AQUIND interconnector - Hampshire County Council's Written Summary of Oral Submissions

Issue Specific Hearing 5 -Environmental Matters and Highways held on Thursday 18 February 2021

Post hearing note on agenda item 7.7 – passing bays on Day Lane

Post hearing note on agenda item 7.9 – out-of-hours working

Plate 6 - Proposed construction traffic management on Day Lane - will be replaced with full page image when issued as PDF

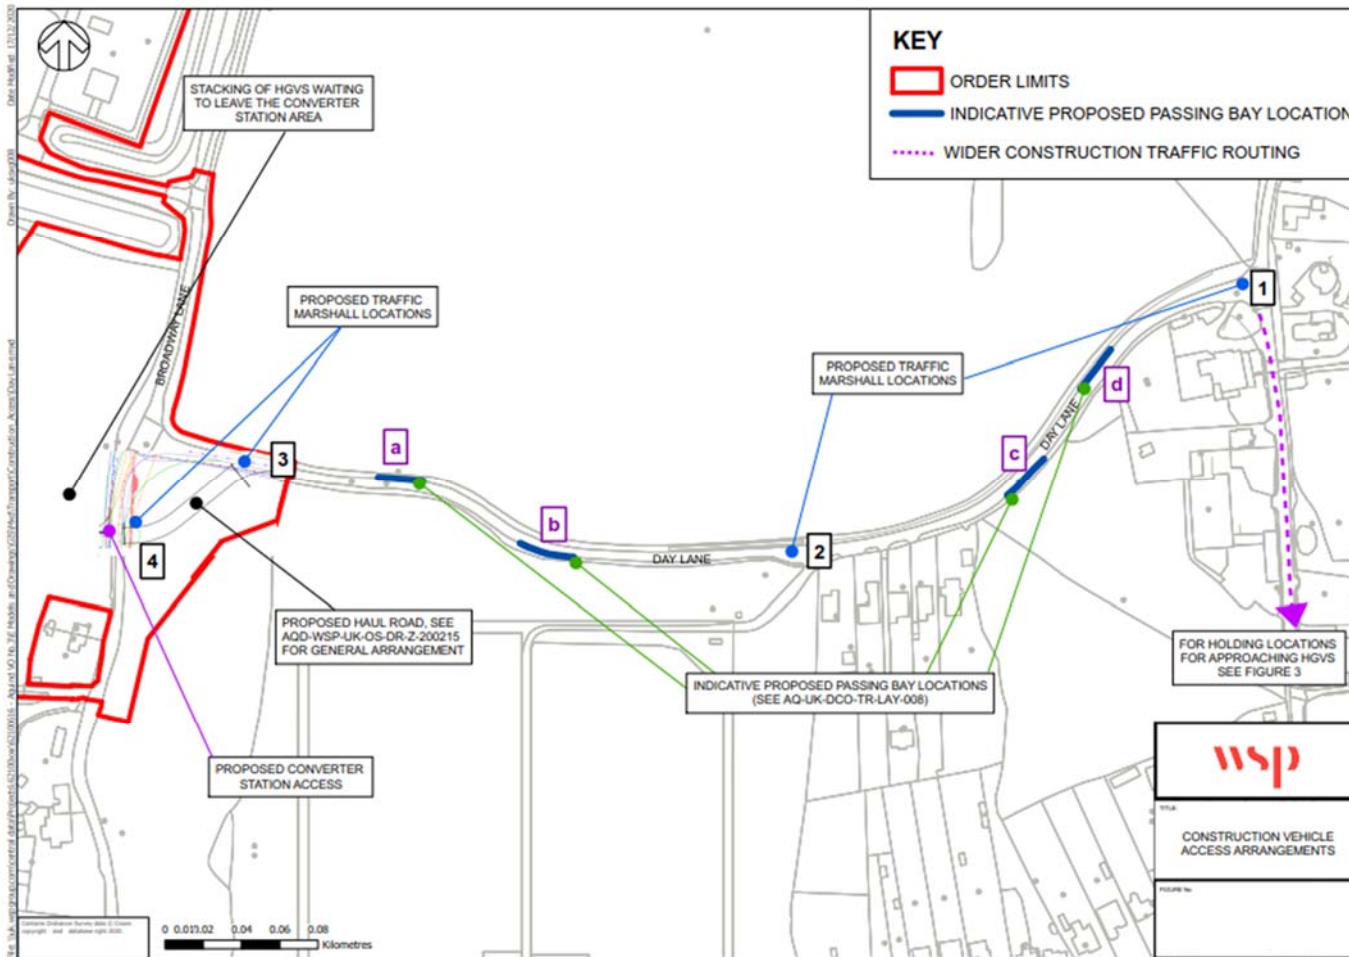
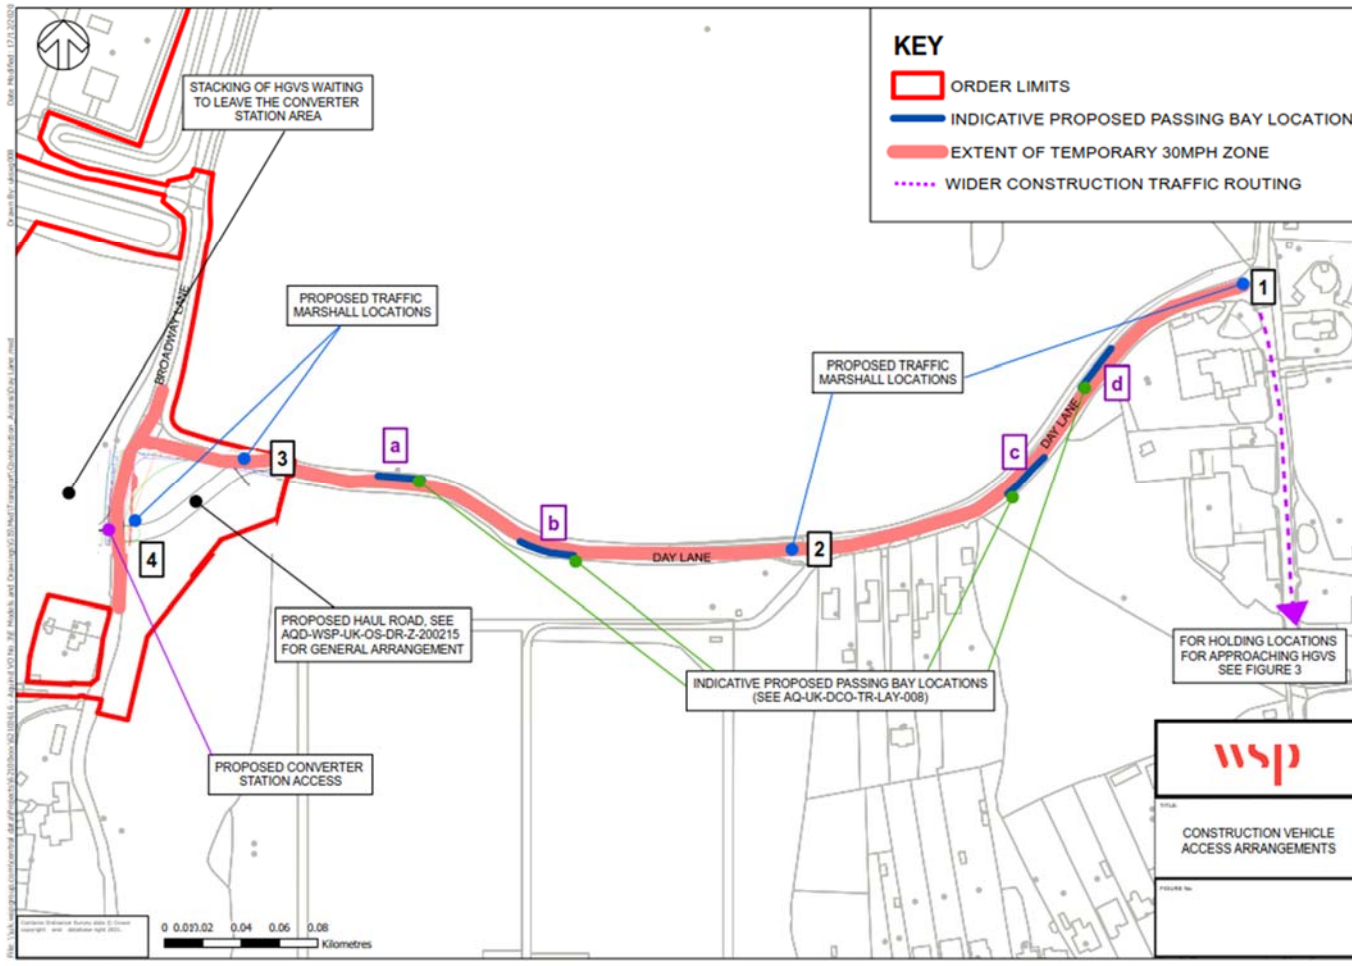
7.6	<p>Has work progressed on the s278 Agreement to secure the facilitation of passing bays on Day Lane? Is Hampshire County Council content with the traffic management measures on Day Lane? If not, why not?</p>	<p>RT – Regarding the S278, the draft is in progress so will hopefully be resolved soon. A few points are left over on the management but parties are pretty close to resolving these outstanding matters.</p> <p>HD – General principle of the works now agreed. The use of the Hulbert Road layby requires a parking suspension. Parking enforcement remains a question as to whether Havant Borough Council officers will undertake this function and where the funding comes from. The layby currently has capacity, but Dunsbury Park is being built out and the layby may be under higher demand as the project builds out. The layby was constructed to provide for existing provisions removed for the Dunsbury Park access works and is currently not being fully utilised.</p> <p>MJ – Looking into parking enforcement issue.</p> <p>HD – Day Lane Management Strategy stated that the strategy would only be in place during peak construction.</p> <p>CW – Confirmed that the strategy would be updated to confirm that it would also be in place outside of peak construction.</p> <p>CW –Existing vehicular access at Broadway Farm will be used to bring plant into site. Otherwise, vehicles would have to stop on the carriageway to drop the materials off. Use of the access not picked up in assessment.</p>

<p>CW – Farm used by tractors to deliver grain. Also used regularly by agricultural machinery. Similarly, management strategy to be employed (traffic marshals, escort vehicle).</p> <p>RT – Raise that there is an issue with the Day Lane/Broadway Lane junction too. Timing point too – County Council have spent a lot of time reviewing and a note will need to be provided ASAP.</p> <p>CW to issue FTMS that evening (Thursday 18 Feb)</p>

The applicant has recently proposed the introduction of passing bays at Day Lane to accommodate HGV traffic during construction. Hampshire County Council (HCC), as Highway Authority, support this measure as it is required to ensure highway safety during construction.

The South Downs National Park Authority (SDNPA) note that Day Lane is outside of, but adjoins, the National Park and that these passing bays will result in a moderate erosion of the rural character of Day Lane. To be taken into account with this landscape impact, HCC consider that the permanent retention of the passing bays would have a moderate benefit for pedestrian safety by providing areas of pedestrian refuge.

1. Whether to retain the passing bays on a permanent basis will be assessed based on actual experience and any relevant data after the completion of construction works for the Aquind scheme.
2. After construction works have completed HCC will consult with both SDNPA and EHDC (as Local Planning Authority) to determine whether the passing bays should be retained on a permanent basis or not.
3. The Section 278 agreement is being drafted with a clause within it that requires Day Lane to be returned to its pre-development state (i.e. the passing bays are removed) if this is determined through the consultation with SDNPA and EHDC to be necessary or desirable.
